**Re: Casitas Del Camino at 120 60th ST NW
Erosion and Sediment Control Plan
Engineer's Stamp Date – 11/20/25 – K11E005A (SWQ-2025-00061)**

Based on the information in your submittal received on 12/11/25, the ESC Plan can't be approved until the following comments are addressed.

9

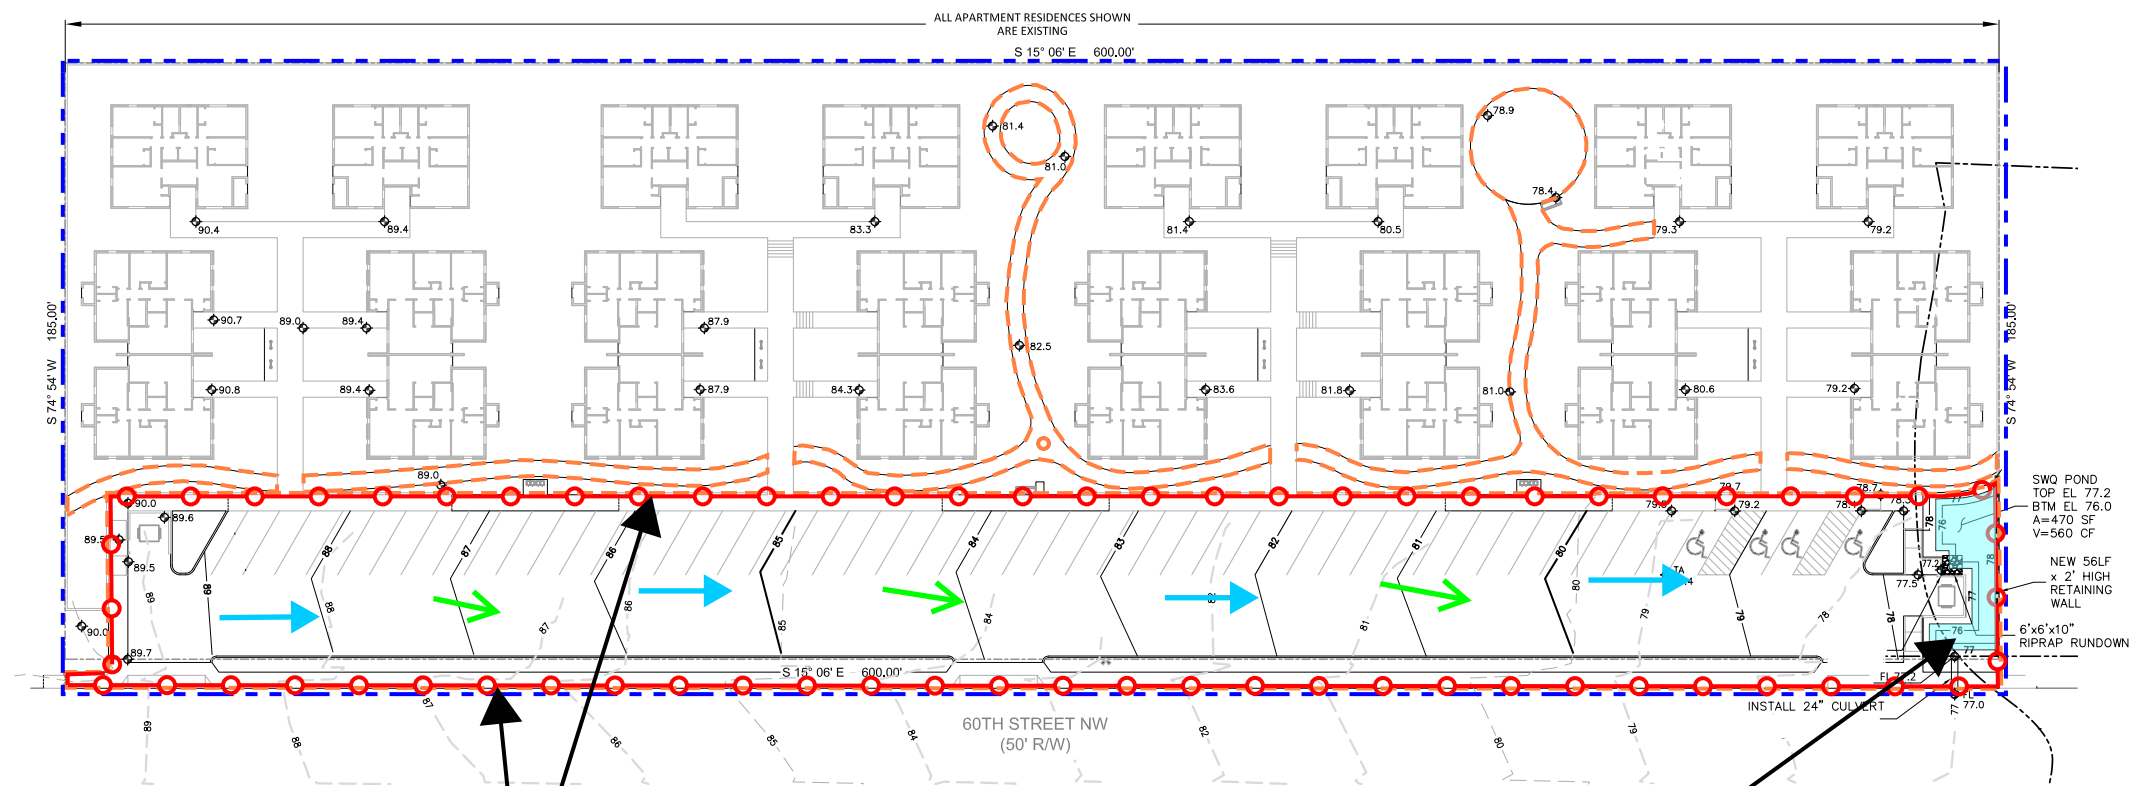
1. The north arrows on sheets 8, 9, 10, and 11 are pointing the wrong way and must be corrected.
2. There aren't enough existing and proposed contours and spot elevations within the existing development west of 60th St. to determine the limits of grading and the drainage patterns associated with all of the new sidewalks being constructed on sheet 8. Proposed contours extend into the southwestern third of the existing development, suggesting regrading of all open space between the buildings. Add these areas to the grading limits on the ESC Plan, and verify the drainage patterns.

3. According to the G&D Plan, the undeveloped part of the site west of 60th St., shown on sheet 8, is supposed to drain to 60th St., even though it doesn't drain there now. Silt fences are not suitable for the large drainage area and concentrated flow along the south edge of the site. Temporary and permanent controls must be identified on the ESC Plan with the capacity to divert the 100-year stormwater runoff across the south edge of the site to 60th St. A temporary Diversion Channel (DC) should be the first item of construction there to remain until after the permanent retaining wall is constructed, as shown on the G&D Plan. Provide a symbol and construction note on the ESC Plan for the temporary DC specifying top elevations for the berm 6" min above the top elevation of the retaining wall. The DC should be offset enough from the property line to allow construction of the retaining wall. Extend that DC and wall all of the way to 60th street with at least 6" freeboard. Provide a typical section through the wall and berm with a normal depth calculation on the ESC Plan.

4. The ponds along the south edge of the site on sheet 8, must also be the first items of construction prior to other land disturbing activities. The notes on the ESC Plan show the same pond volumes as the G&D Plan. However, the required temporary pond volume is much larger than the post-construction volume shown on the G&D Plan. You must *"design and install all stormwater controls in accordance with good engineering practices, including applicable design specifications"* per CGP 2.1.3. The NMED requirements in CGP 9.6.1.c.i state: *"The SWPPP must also describe design specifications, construction specifications, maintenance schedules (including a long-term maintenance plan), criteria for inspections, and expected performance and longevity of these BMPs."* The design calculations and temporary construction specifications must be
